Our Ref: BR/63/19/PL

19th March 2019

**Town & Country Planning Act 1990 (as amended)
Town and Country Planning (Development Management Procedure) (England) Order 2015
Application for Full Planning Permission**

Development Demolition of existing building and erection of 6No. three bedroom dwellings with associated accesses and car parking.
Location 15-17 Kew Gardens Bognor Regis

BLOCK PLAN (1:500)

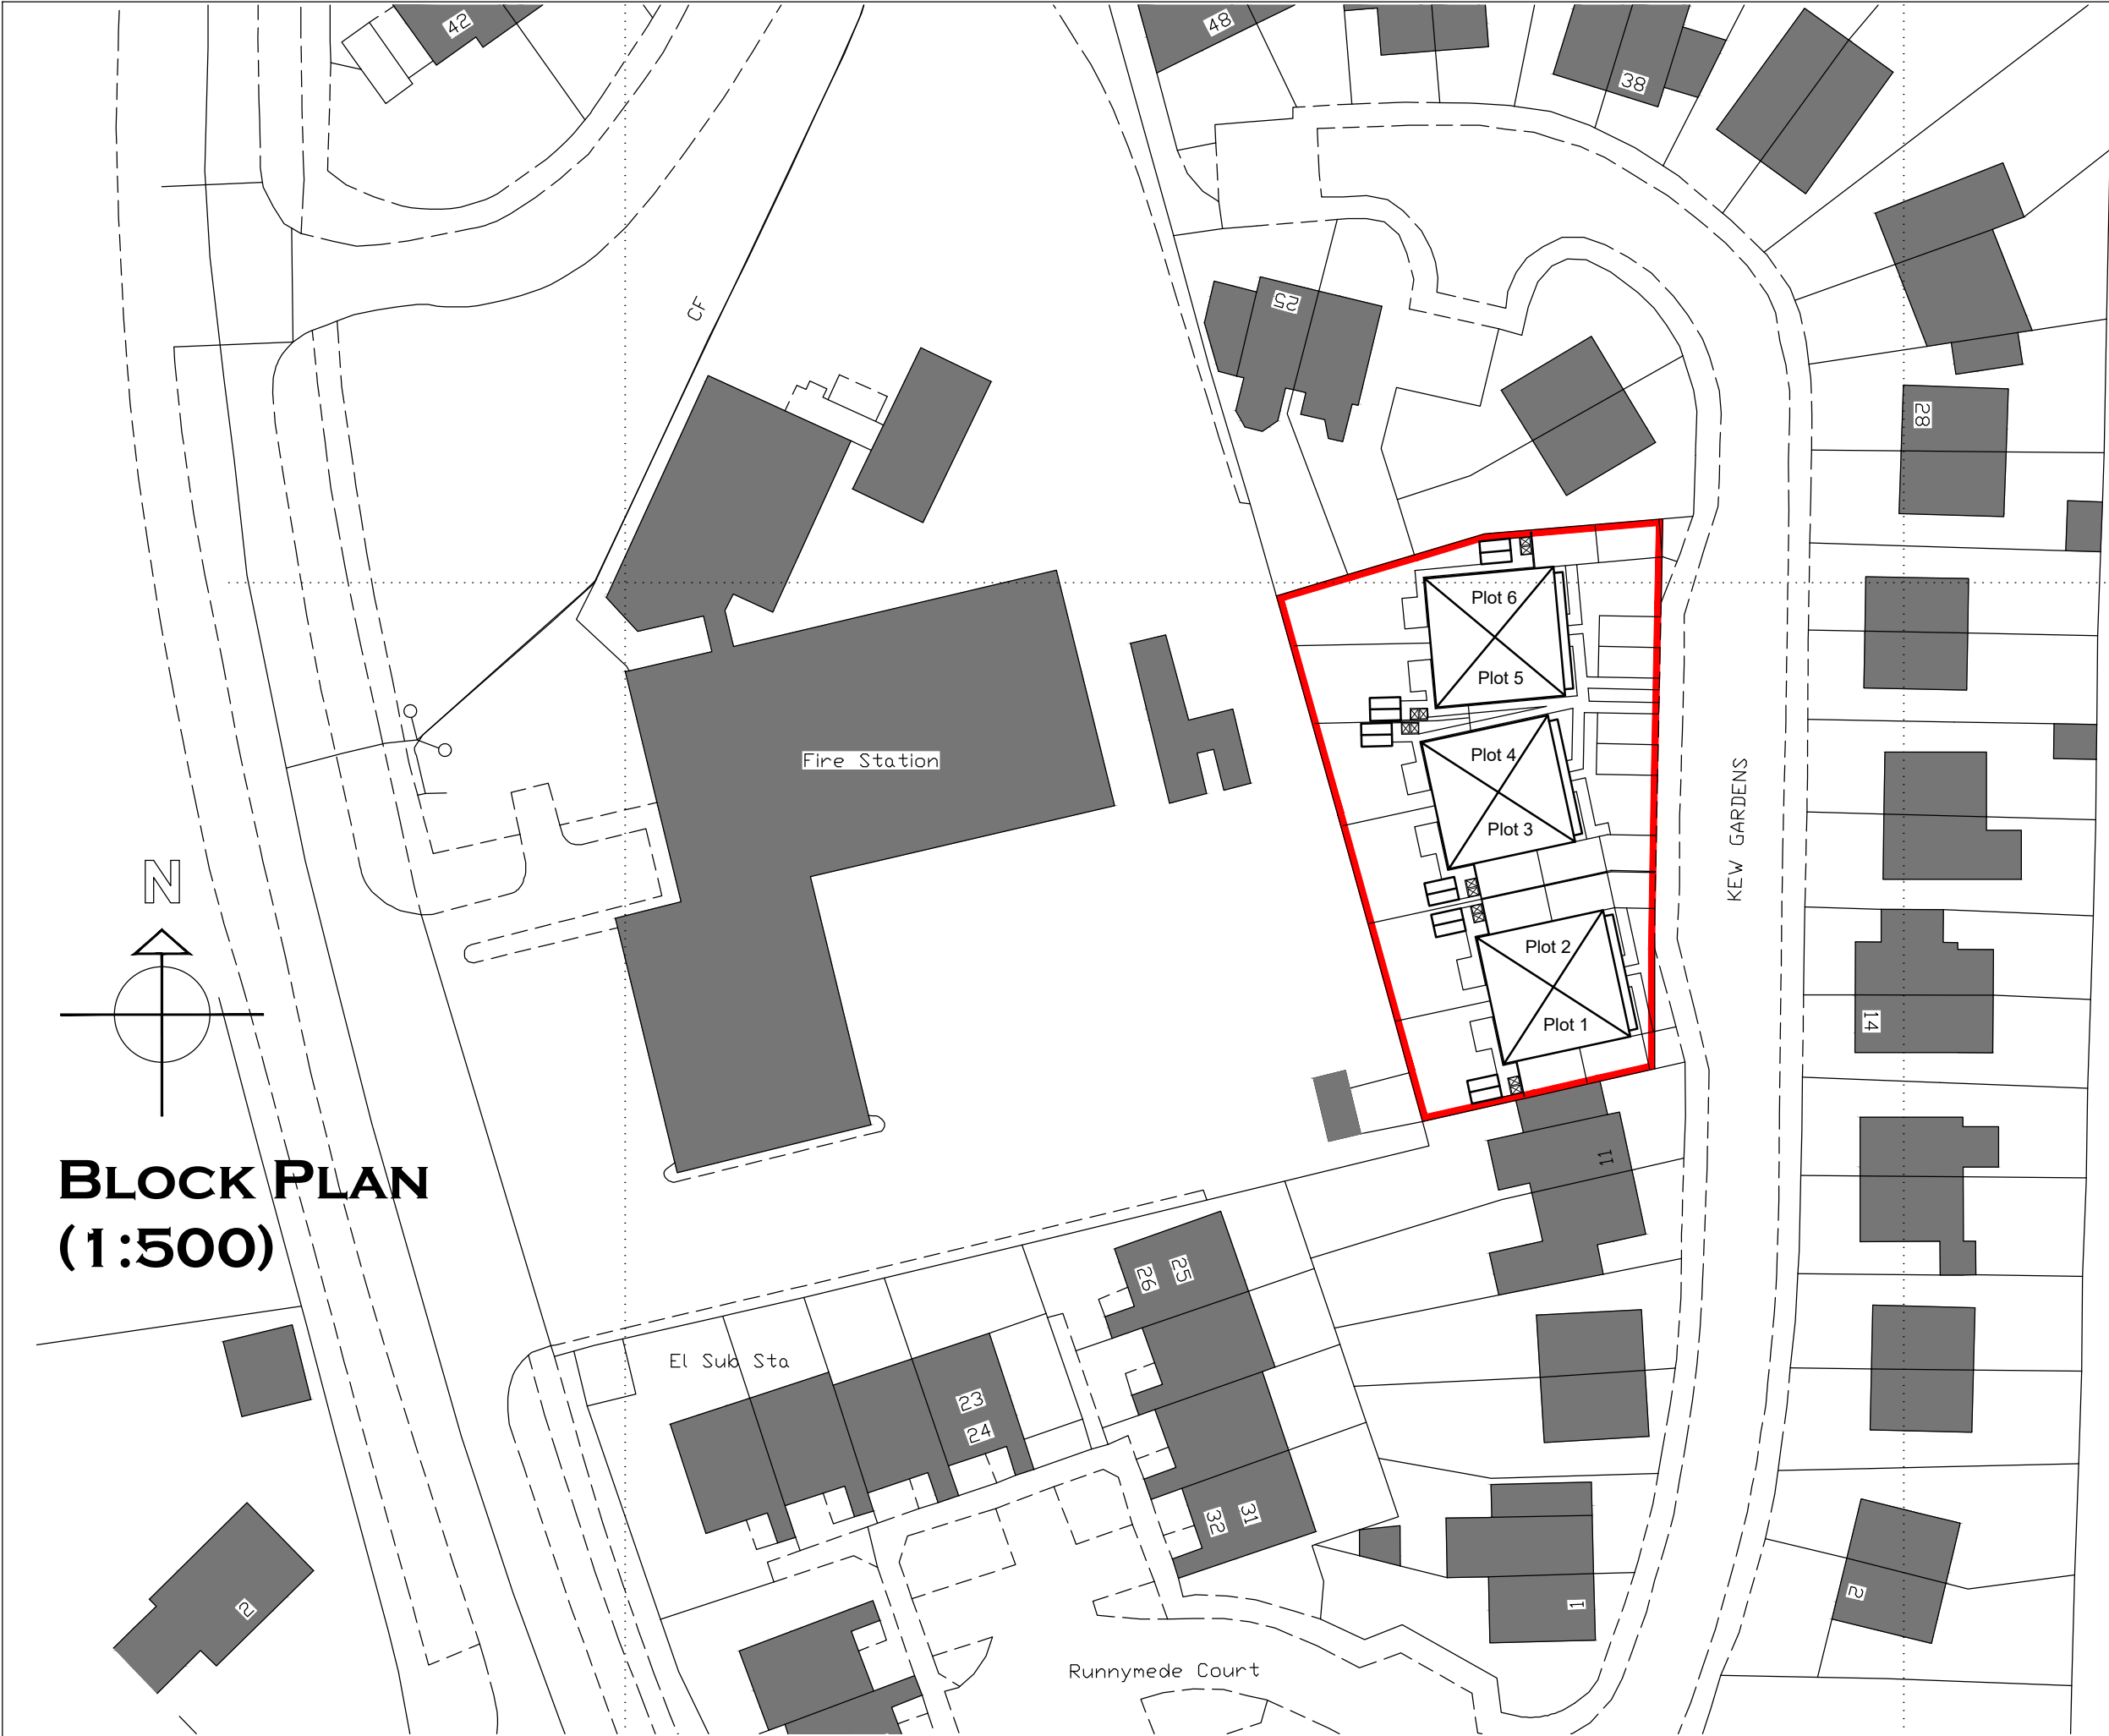
Block Plan

Please submit 1 electronic or 3 paper copies of an amended block/site plan at a scale of 1:500 or 1:200 to show visibility splays from access points

Project:-			
Proposed Residential Development 15-17 Kew Gardens Bognor Regis West Sussex			
Title:-			
Site Location Plan			
Client:-			
Farnden Developments Ltd			
Scale:-			
1:1250 (@A3)			
Drawn By:-	PJD	Checked By:-	
Date:-	14/02/19	Date:-	
Job.No:-	180037	Drg.No:-	01
Rev:-

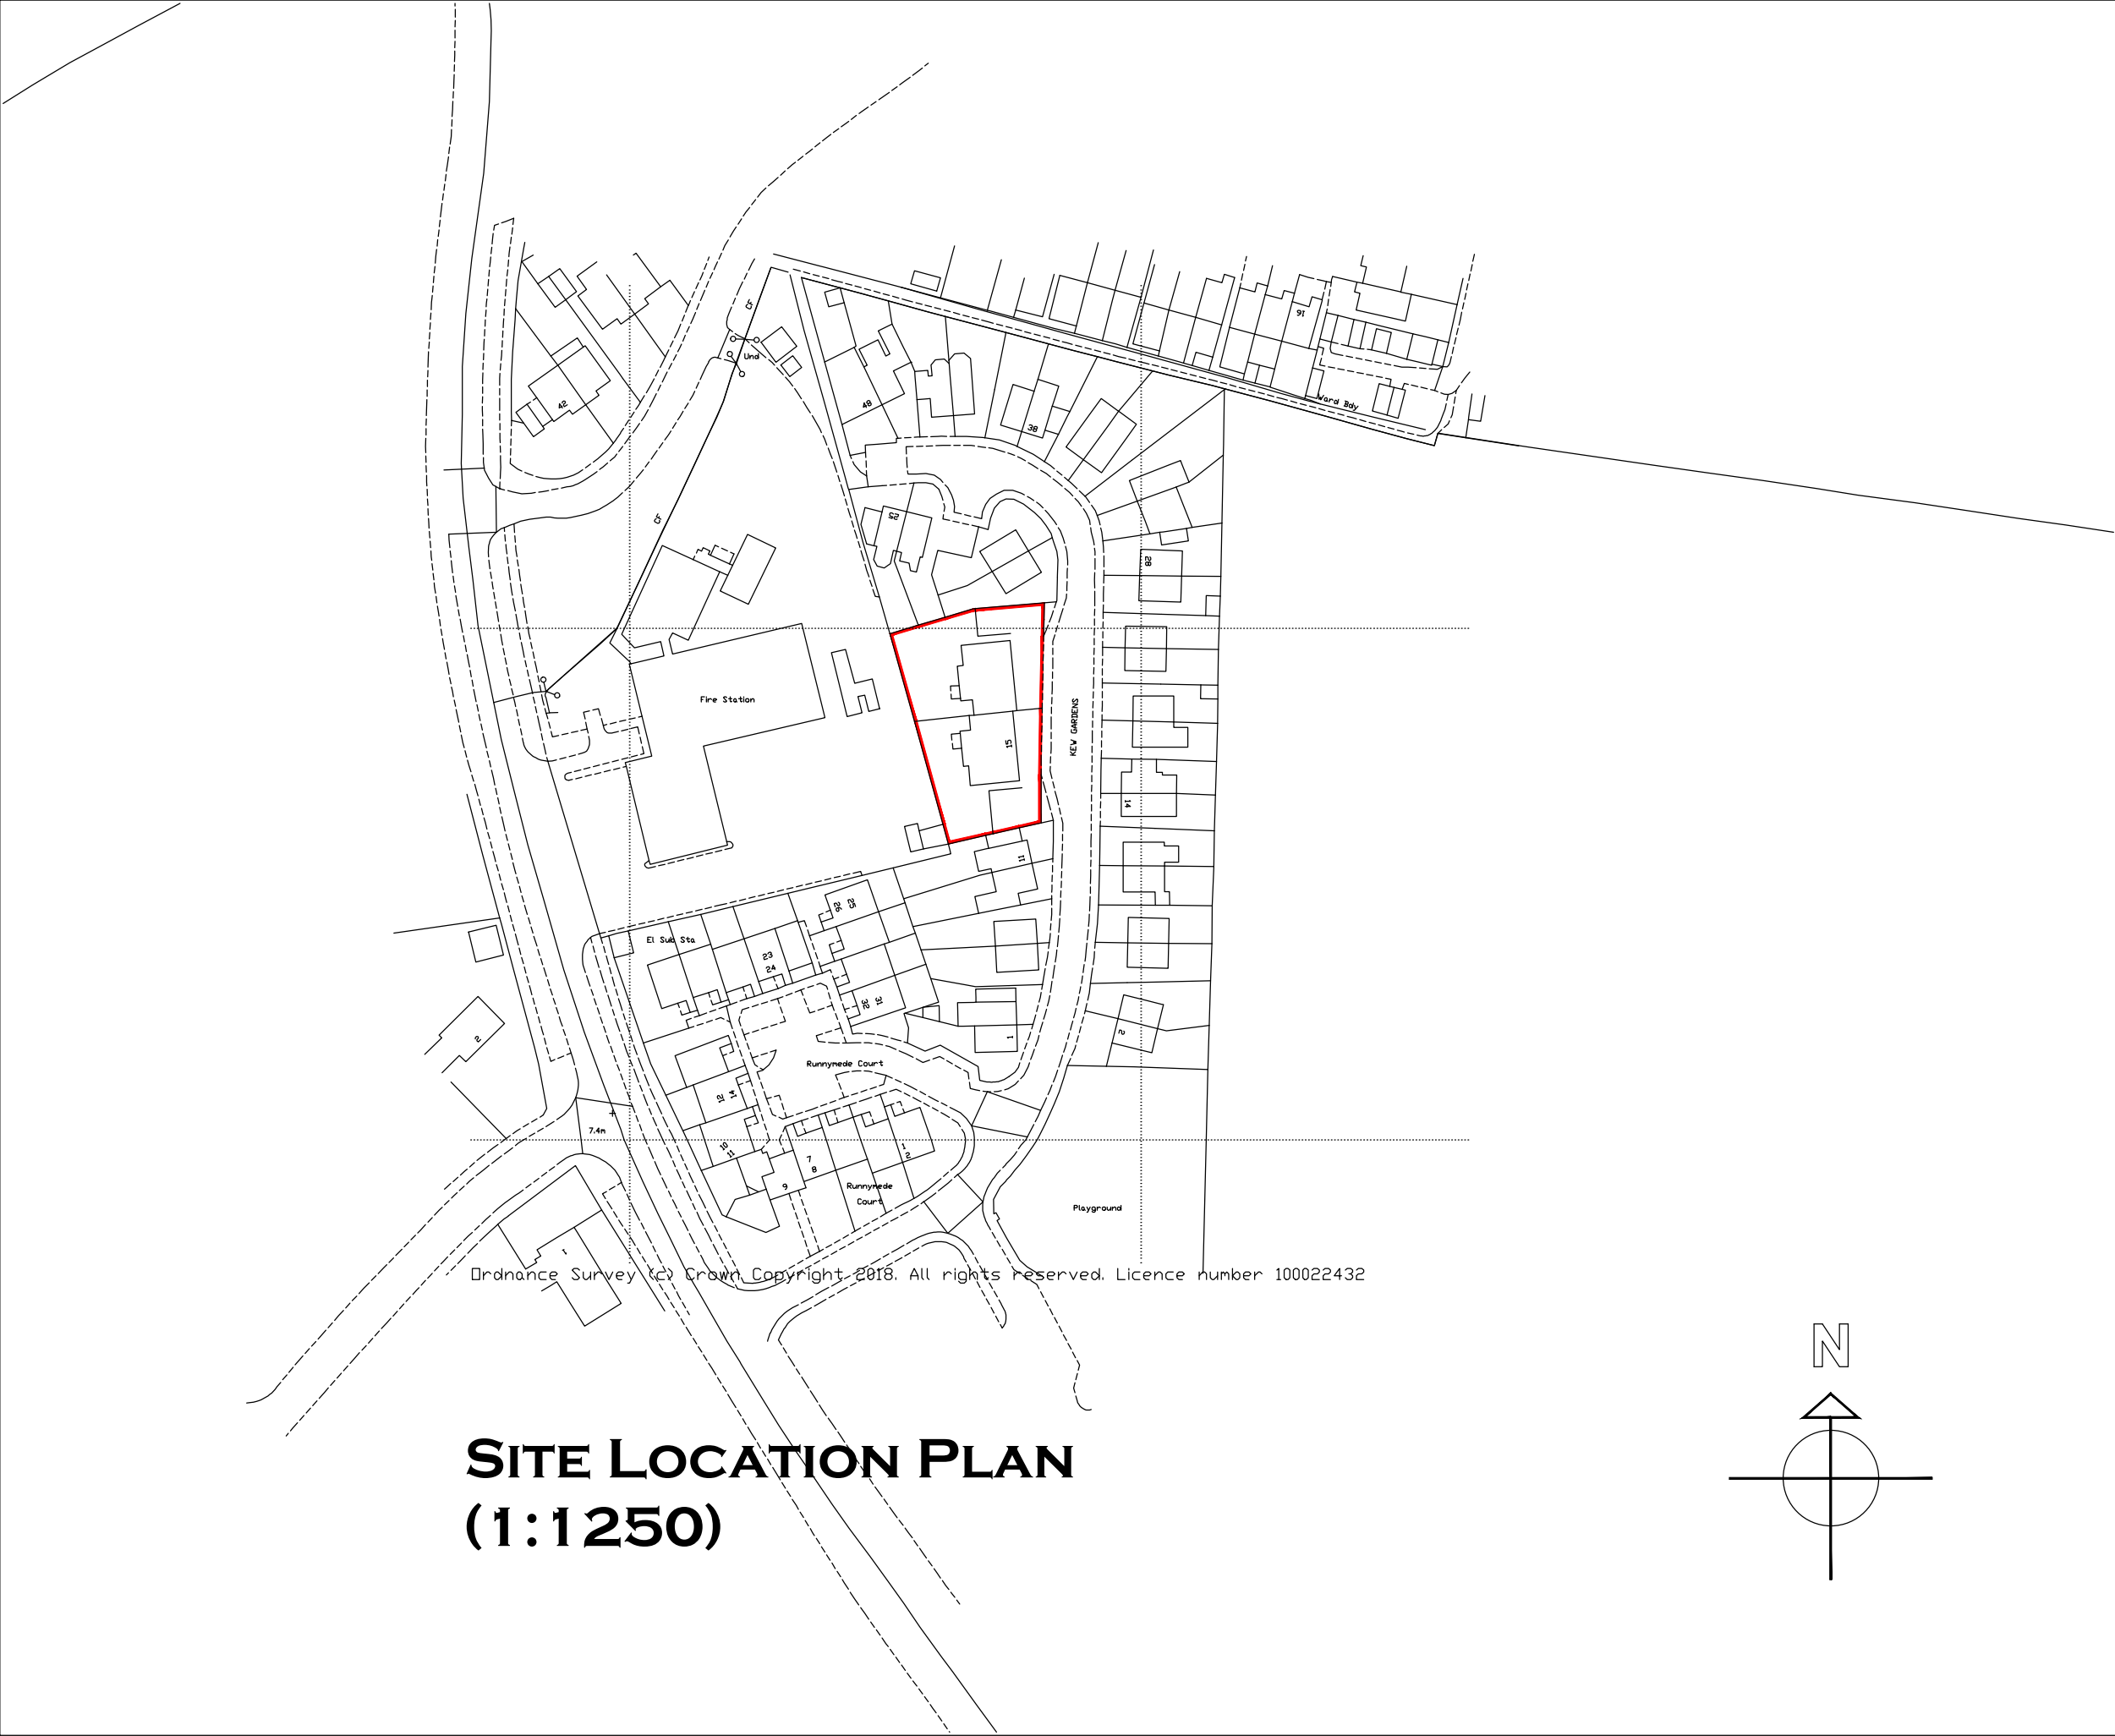
Location Plan

Please submit 1 electronic or 3 paper copies of an amended location plan at a scale of 1:1250 or 1:2500 for rural areas to include highway land edged in blue. You will also need to serve notice on West Sussex County Council Highways land and update Certificate B to show this.
